re: Geotechnical Review – Grading Plan
Proposed commercial Development
30 Frank Nighbor Place - Kanata, ontario

file: PG6153-MEMO.01

Grading Plan Review

**DRAWING NAME**  
GRADING AND EROSION & SEDIMENT CONTROL PLAN

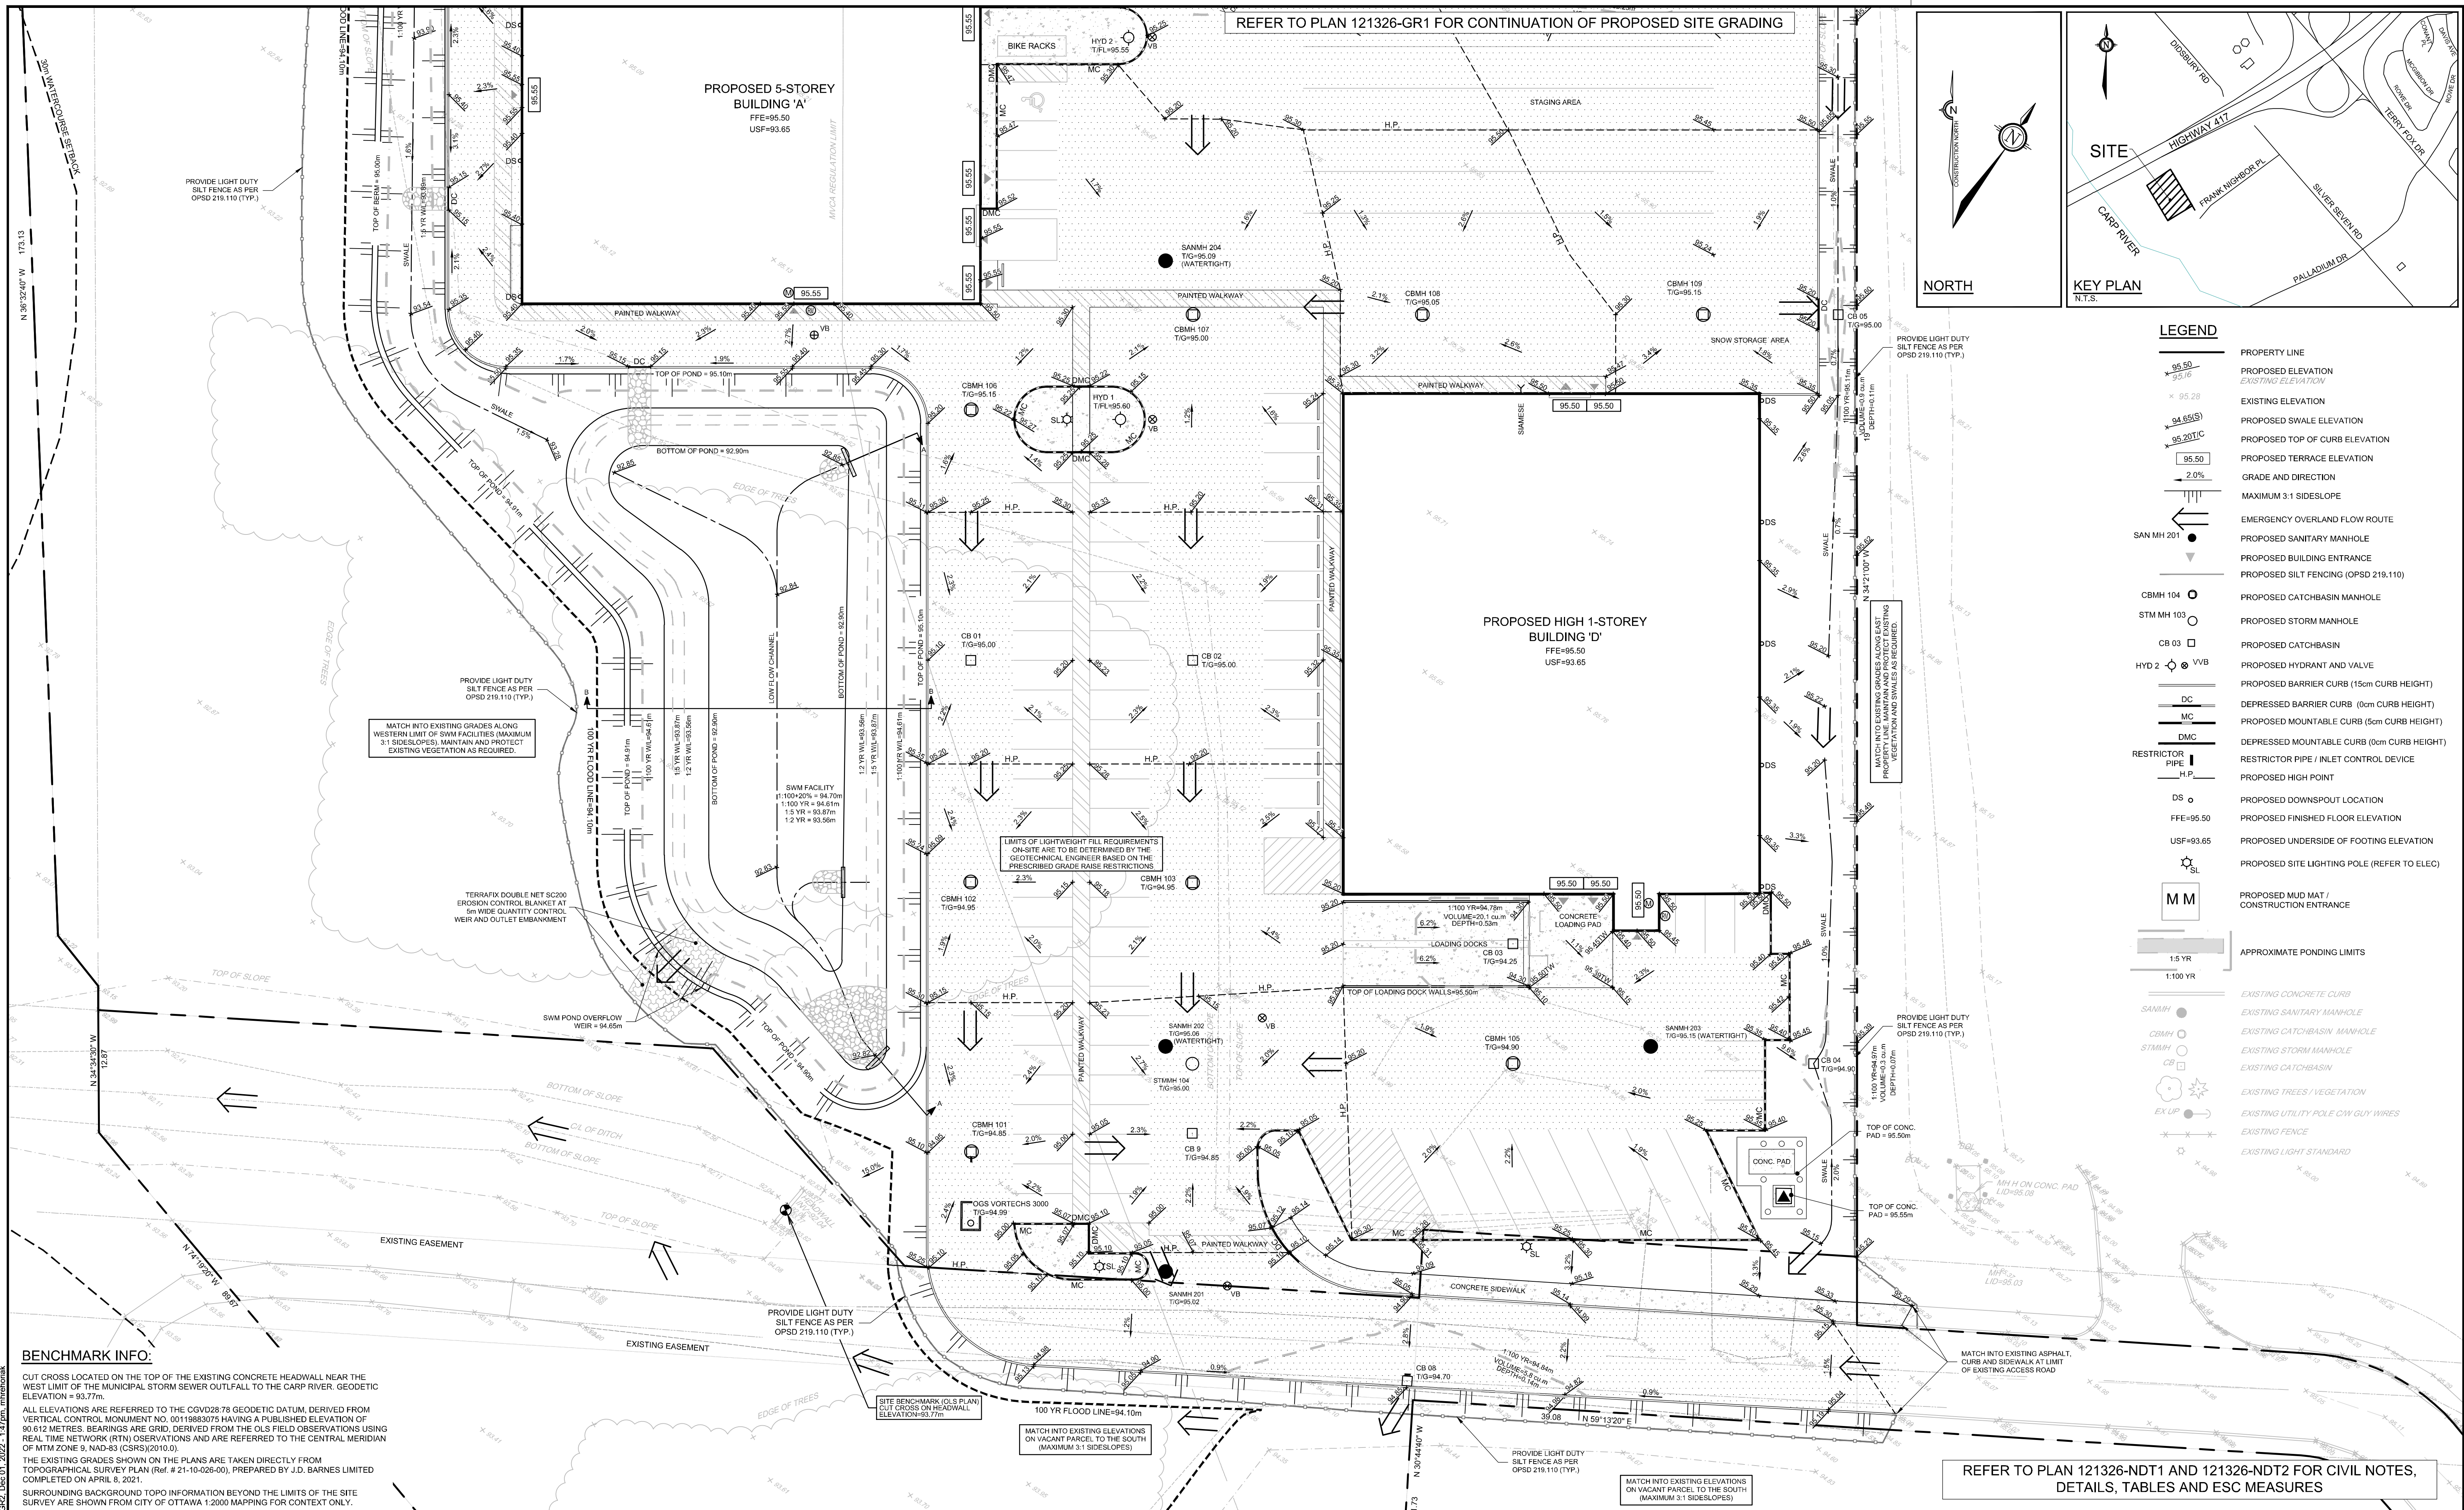
Based on our review of the above noted drawing, the proposed grading for the portable buildings B, C and D meets our recommended permissible grade raise recommendations provided in the geotechnical report. Therefore, no lightweight fill is required for the buildings B, C and D. However, Building A exceeds the permissible grade raise recommendations. Our grading summary and lightweight fill recommendations are presented in Table 1 – Soil Matrix Summary attached

The LWF material should consists of EPS 19 under the slab on grade, EPS 12 around the reminder of foundation under landscaped area and EPS 15 should be used below paved areas. The LWF should be placed against the foundation wall, above the footing and a minimum of 300 mm below the finish surface. The LWF EPS blocks should extend a minimum of 2.4 m outside the foundation wall with the thicknesses recommended in the attached Table 1.
